**KIRKLEES METROPOLITAN COUNCIL
INVESTMENT & REGENERATION SERVICE**

Reference No:	2025/62/91019/W
Site Address:	Fartown Village Hall, Ball Royd Road, Fartown, Huddersfield, HD2 1AN
Description:	Change of use from village hall F2(b) to mosque F1(f)
Recommending Officer:	Edward Cheseldine

DECISION – CONDITIONAL FULL PERMISSION

Officer Report

Description
 PROPOSED GROUND FLOOR PLAN OVERLAID ON SITE PLAN

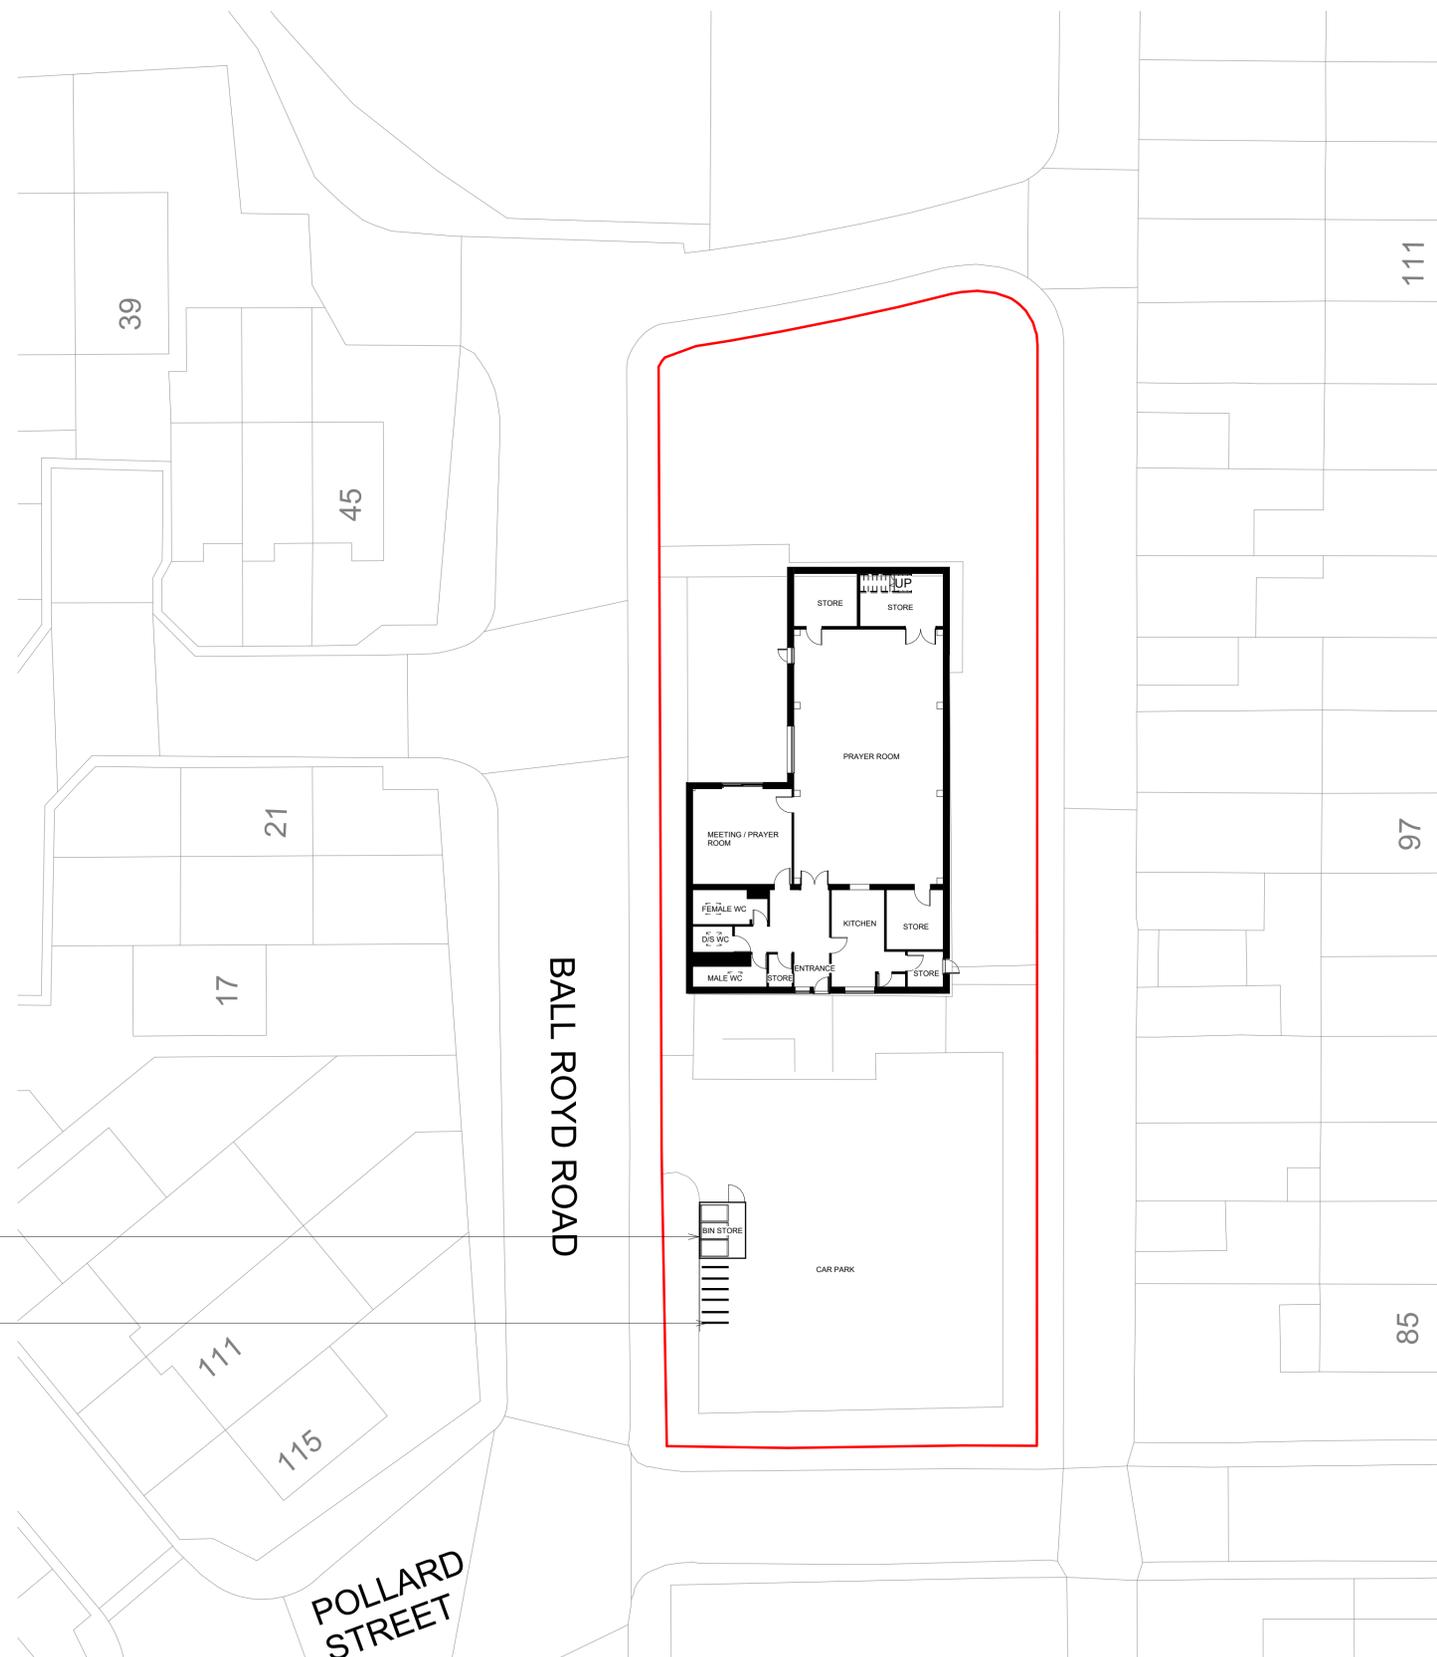
5. Notwithstanding the submitted plans, 1.80m closed panelled fencing and gates shall be erected around the areas indicated as bin storage areas on site plan (100)04 revA and thereafter retained. Gates shall be lockable. The fencing and gates shall be retained thereafter.
